STAGE 1 ROAD SAFETY AUDIT

Bicester Gateway RM

Project: Bicester Gateway RM

Drawing No. 7081-059 Proposed Masterplan

DRAWING NUMBER: **226701_PD01** REVISION: .

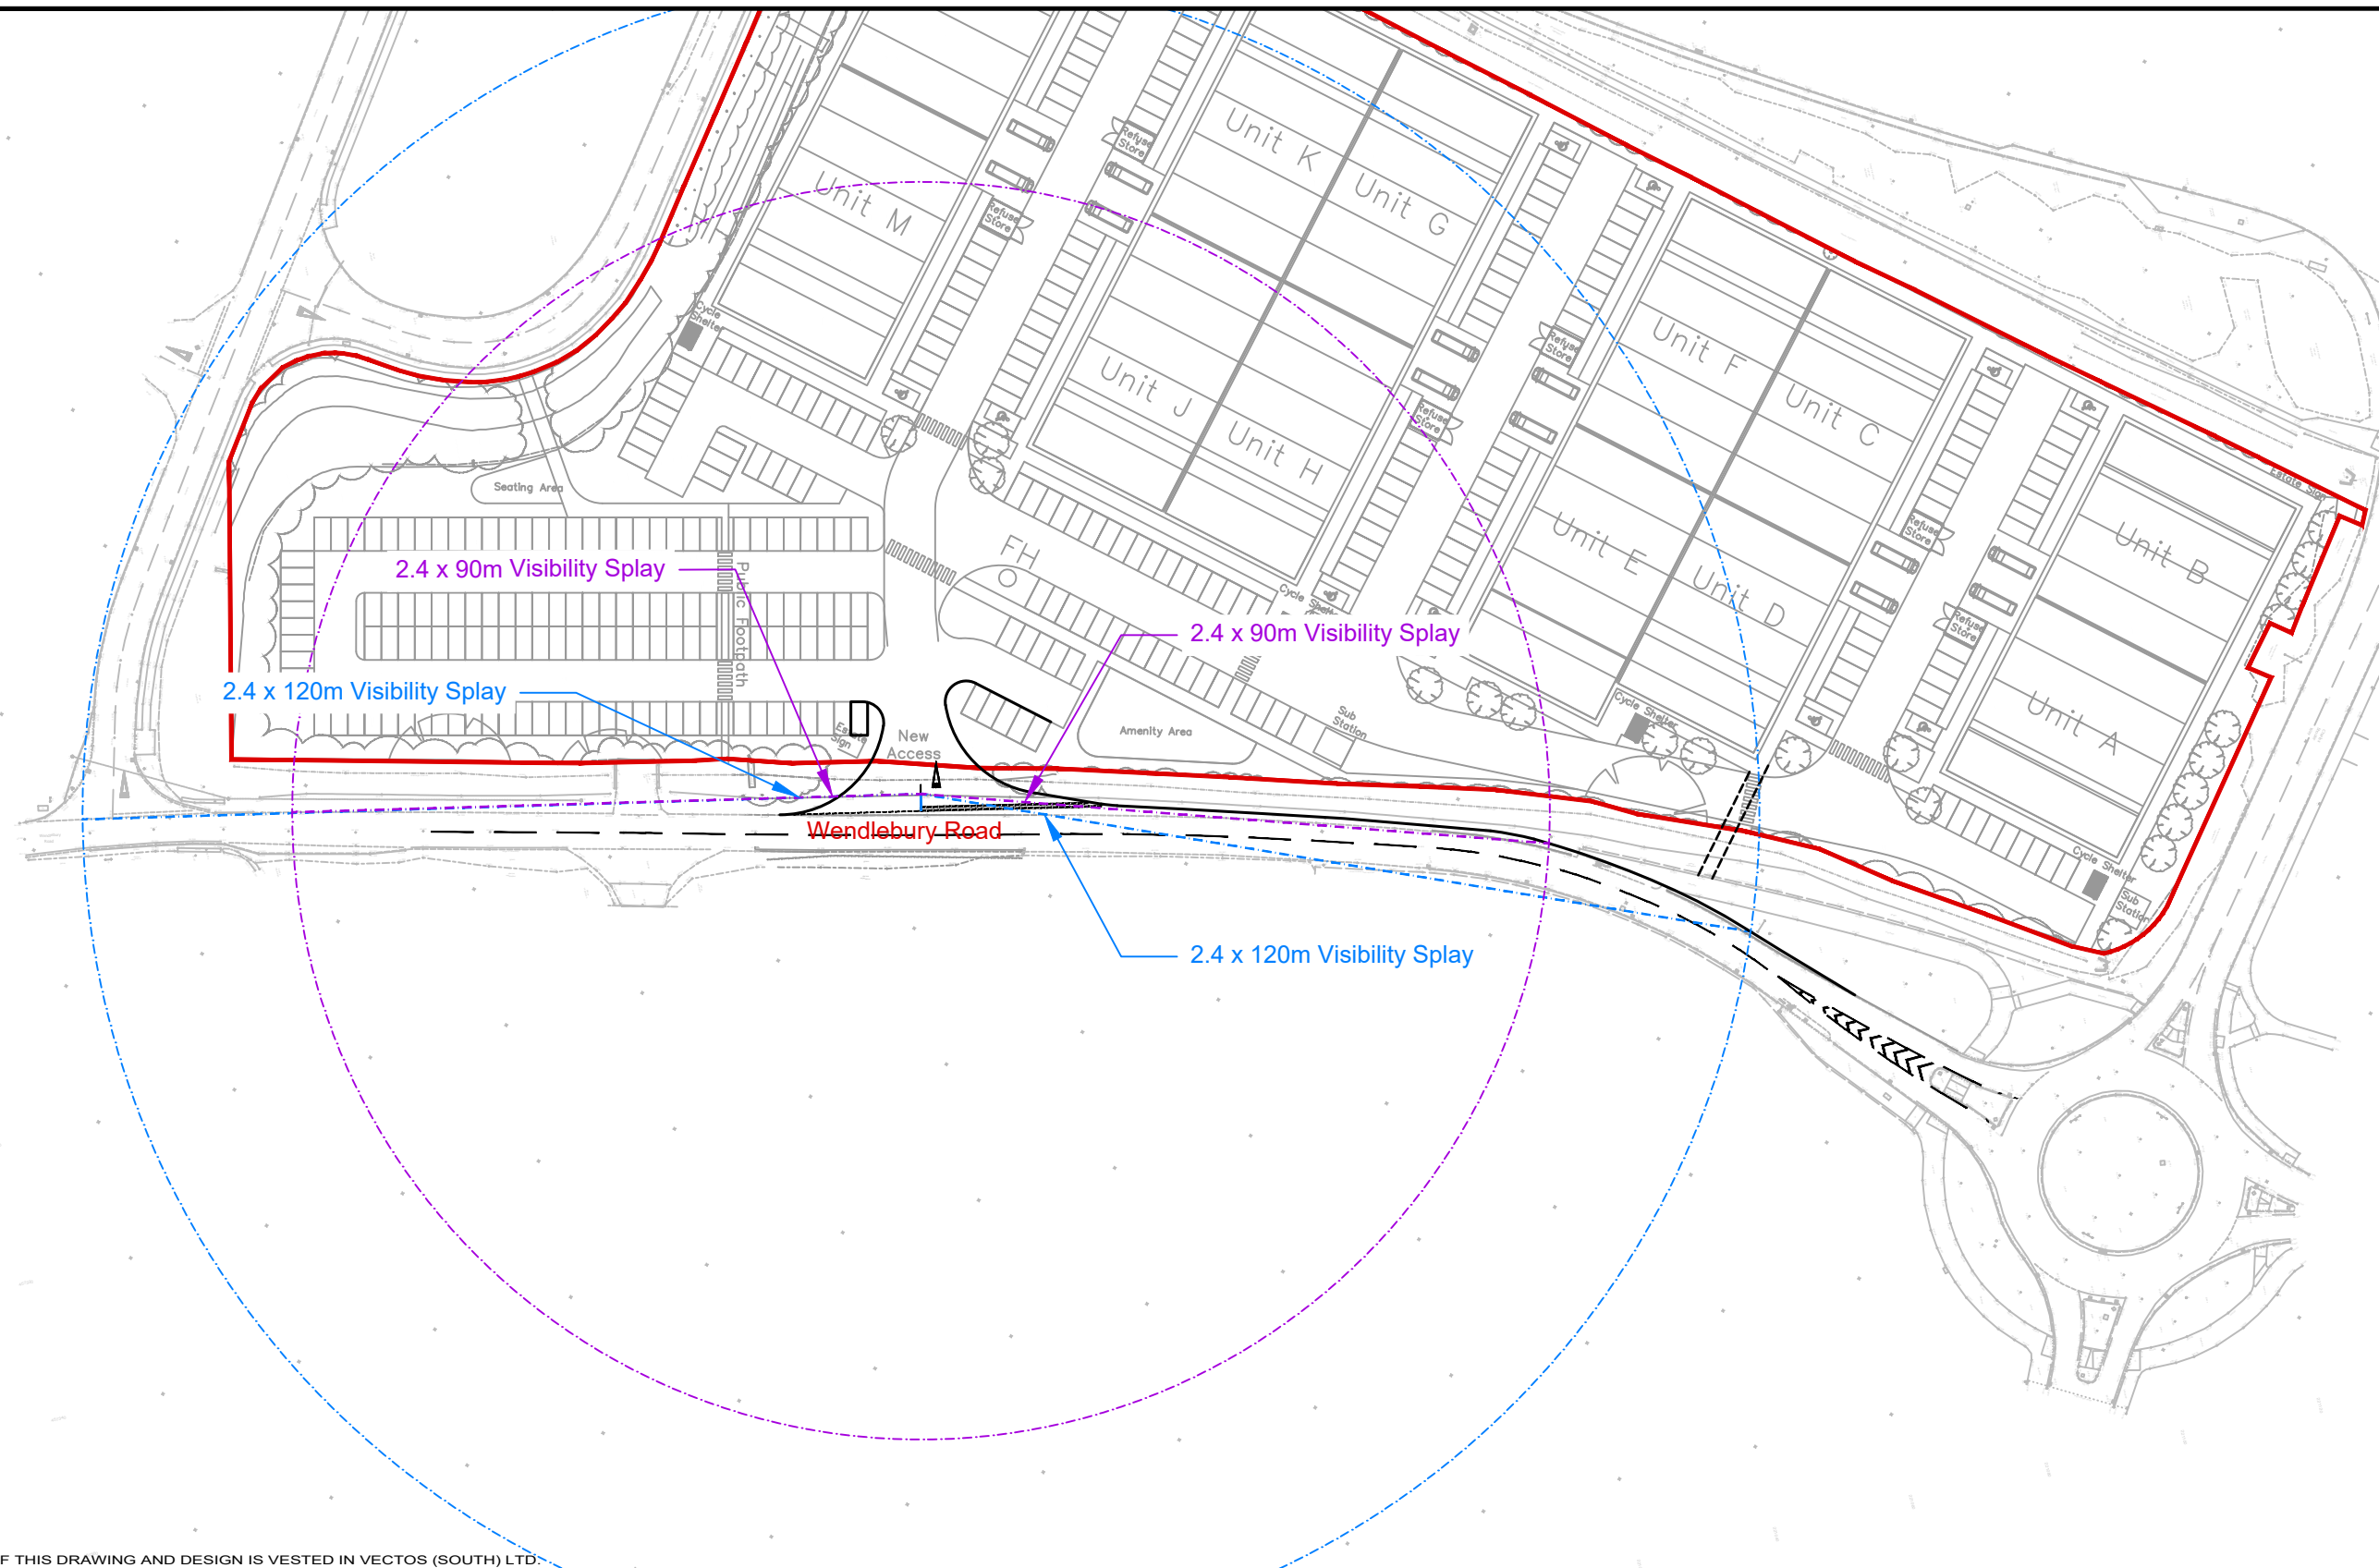
Location A: Shared use cycleway / footway south of A41.

Summary: Lack of hazard warning tactile paving where footways leading into the site meet the shared use facility may lead to confusion between road users and in turn cause collisions between cyclists and pedestrians.

Design drawings indicate the proposed creation of a shared use cycleway / footway facility to the south of the A41. This shared use facility will connect to the development via footways into the relevant car parks. The designs do not provide the required hazard warning tactile paving where the footways join the shared use facility. This arrangement may lead to confusion between road users and in turn cause collisions between cyclists and pedestrians.

It is recommended that the appropriate tactile paving is provided at all interfaces along the new shared use facility.

Location B: Shared use cycleway / footway, eastern extents, uncontrolled crossing.

Summary: Visibility to the right for users approaching the uncontrolled crossing eastbound is severely restricted and may lead to collisions between cyclists / pedestrians and vehicular traffic.

To the east of the proposed cycleway / footway is an existing uncontrolled crossing facility. The existing crossing in this location is flanked by established vegetation and as such does not provide the required intervisibility from the crossing point to approaching traffic. This arrangement may lead to injudicious crossing movements potentially causing collisions between cyclists / pedestrians and vehicular traffic.

It is recommended that the appropriate visibility splays are provided free from obstruction in this location.

DRAWING NUMBER: **226701_PD02** REVISION: .

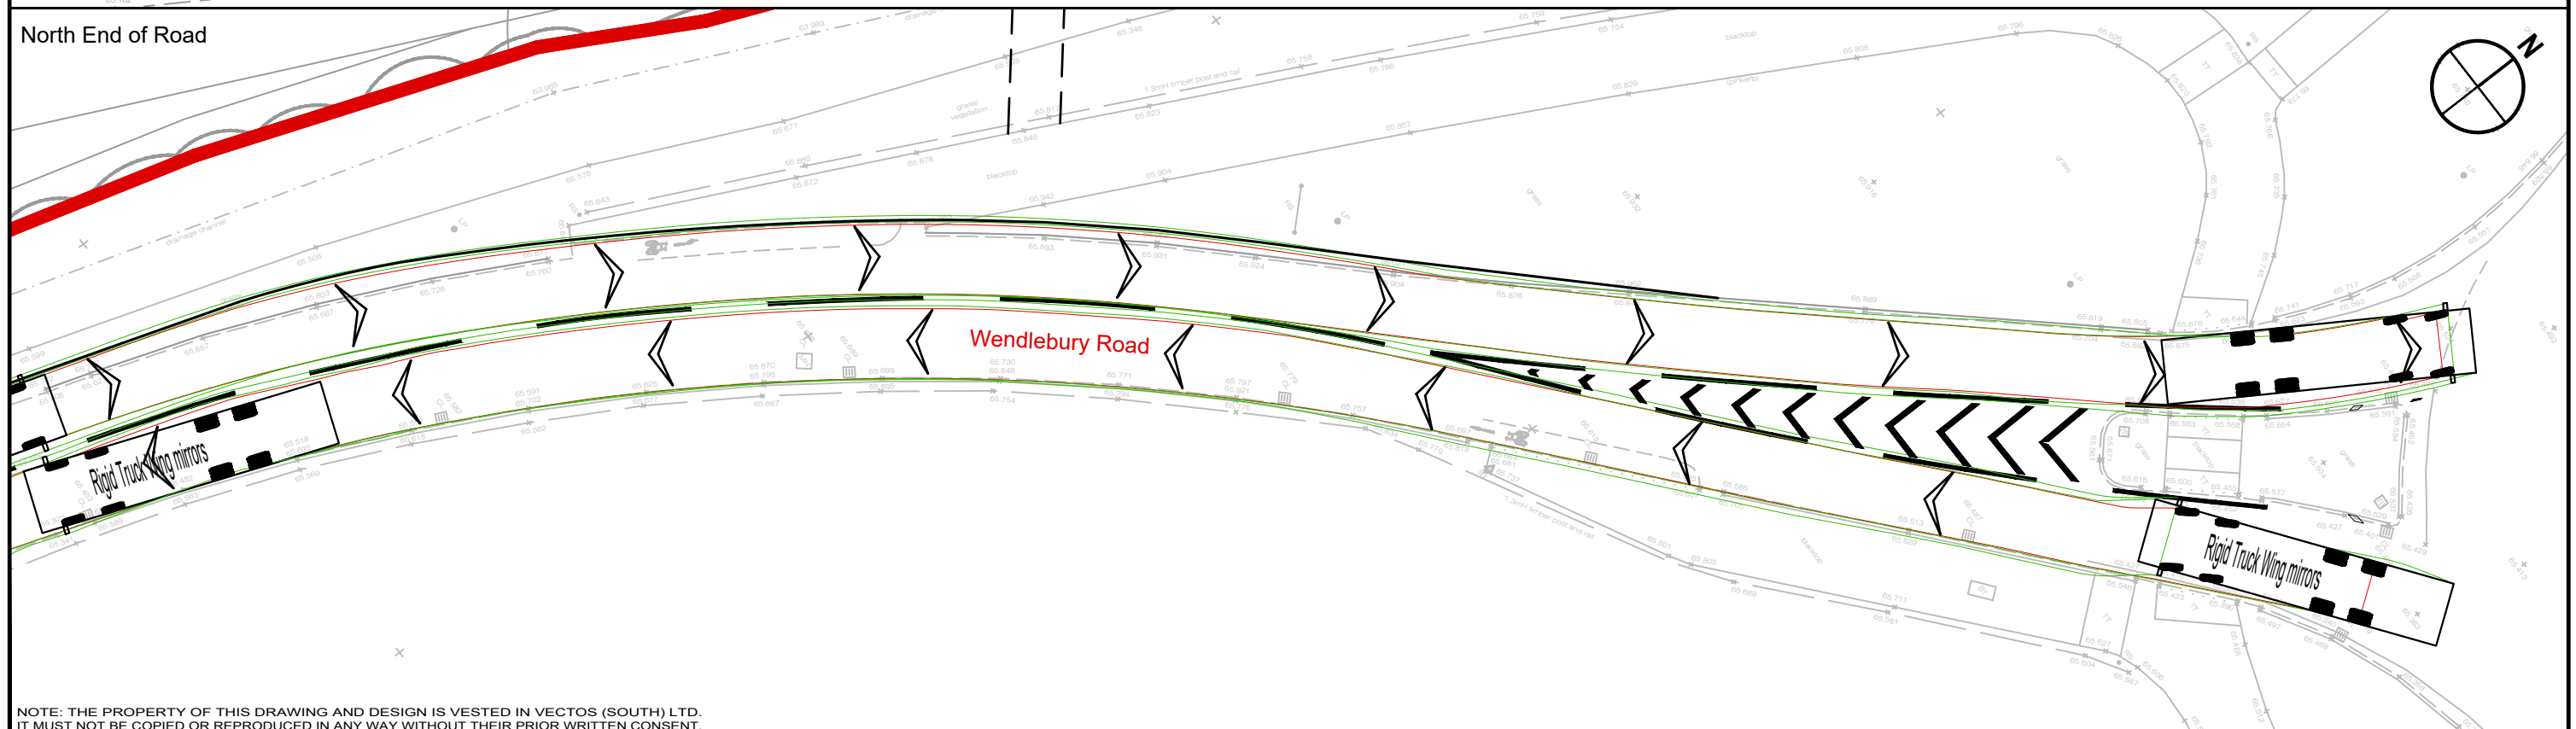
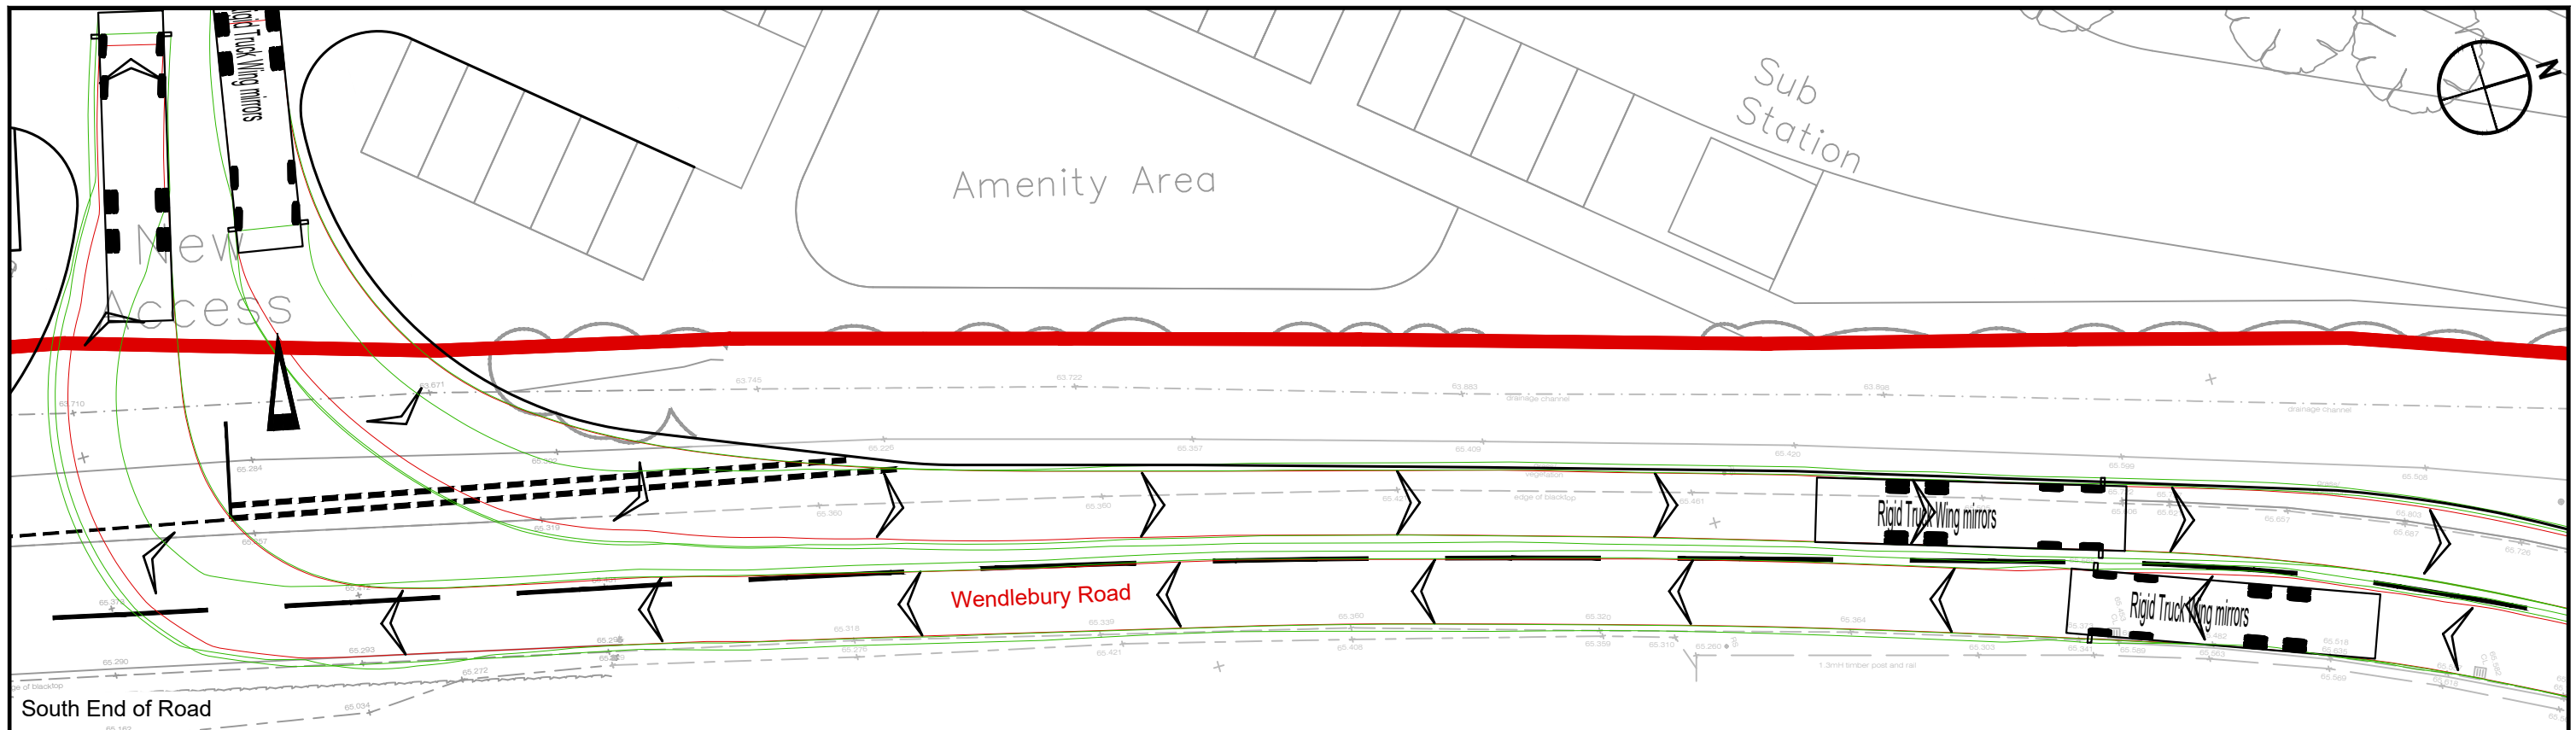
Location C: Wendlebury Road, northern end.

Summary: Junction visibility splay cuts through 3<sup>rd</sup> party land which may obscure visibility potentially leading to shunt / side swipe type collisions on Wendlebury Road

Design drawings show visibility to the east from the HGV access junction will cut through an area of 3<sup>rd</sup> party land to the south of Wendlebury Road. This obstruction to the required visibility splay may lead to injudicious access / egress movements and potentially cause side swipe / shunt type collisions at the junction.

It is recommended that the appropriate visibility splay in line with vehicle speeds is achieved and maintained free from obstruction.
